Issues with the application route

The application route between landfall at Blackpool Airport and Penwortham substation has serious flaws and insurmountable impacts and should not be consented, even without considering alternatives, but as demonstrated below there is in addition a much more convenient alternative.

**Figure 1.2: Biodiversity Benefit Area at Lea Marsh**

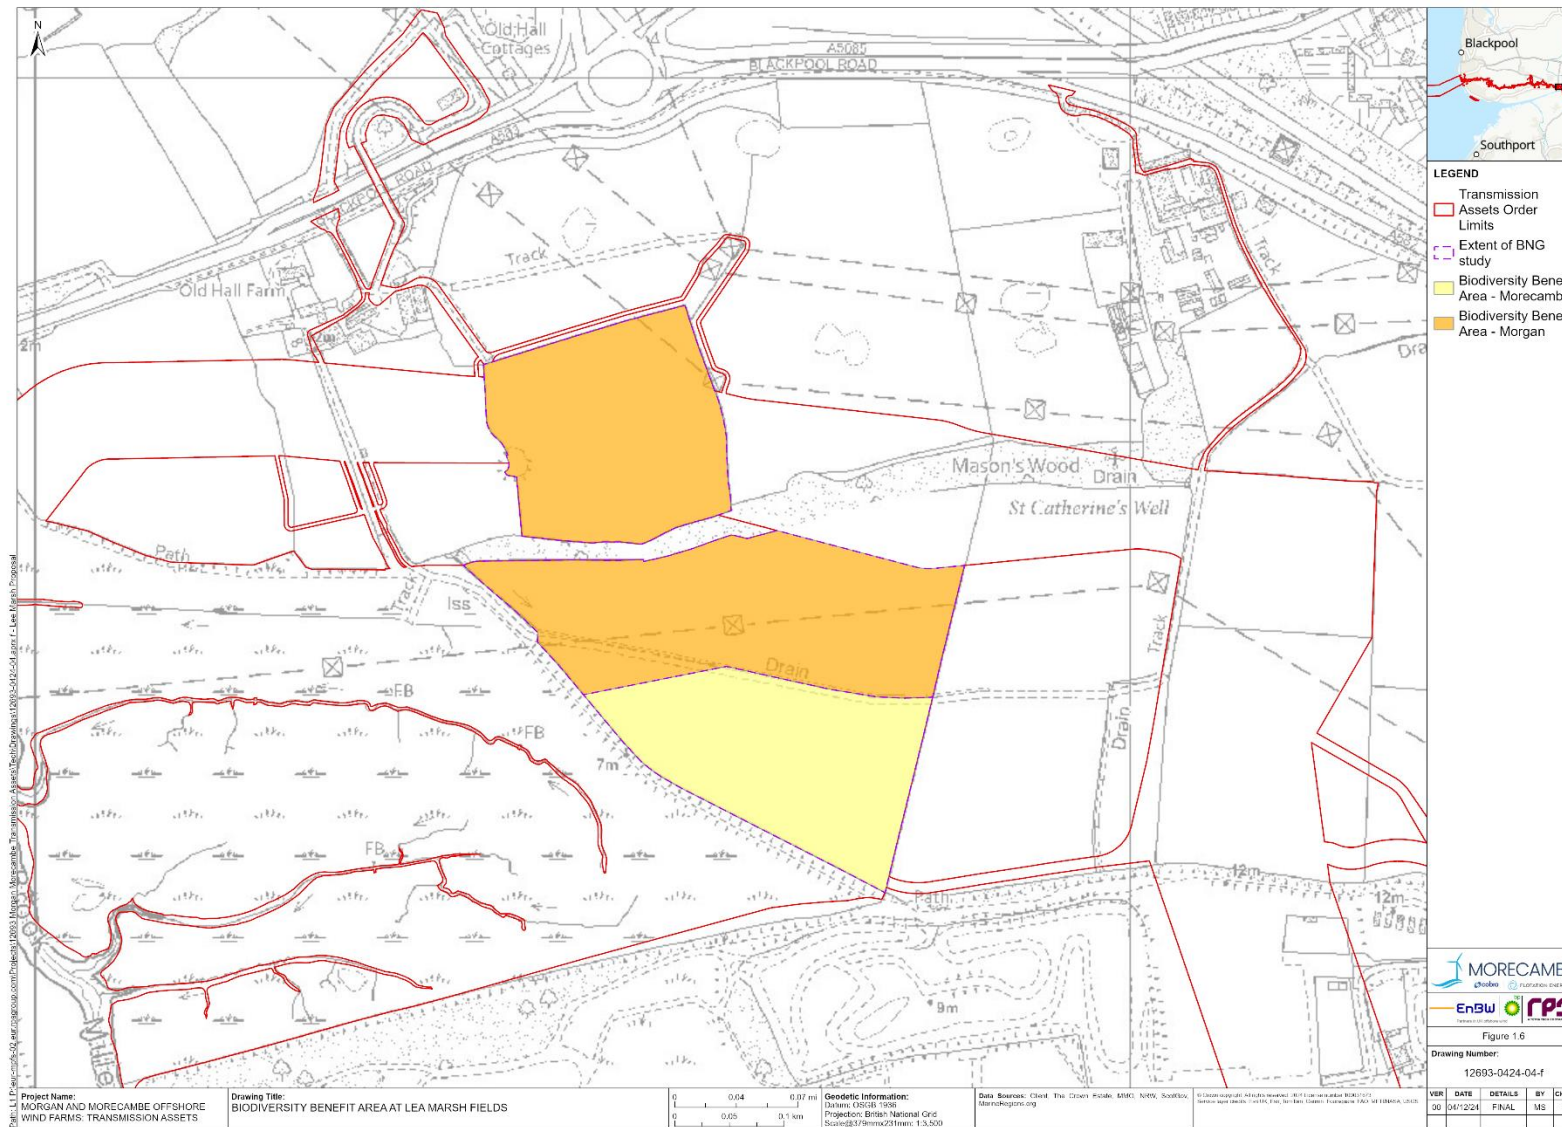
As was heard at the hearing (or at least not disputed when questioned by the Examining Authority), the Applicants have failed to assess the proposed environmental enhancement area at Lea Marsh Fields for increased risk of bird strike at Blackpool Airport and Warton Aerodrome and may therefore either add an unacceptable risk to human life or if it reduces the enhancement area, not provide adequate ecological mitigation. The proposal only assesses lost habitat at the proposed permanent infrastructure and not along the cable route, when (page 34 of) [biodiversity rules](#) require the inclusion of habitat that will not be fully restored to its original type and condition within two years of being impacted, so biodiversity losses are being significantly under-reported.

Any reduction in the quality of (the permanent) habitat at Newton March, Lytham Moss, Freckleton Marsh and Lea Marsh to discourage birds from visiting it will have a consequential effect on the biodiversity score so it may not be possible to satisfy BNG requirements (admittedly not yet a legal obligation but recommended in policy) and avoid increasing bird strike risk. The proposed habitat can be found on page 56 of APP-106
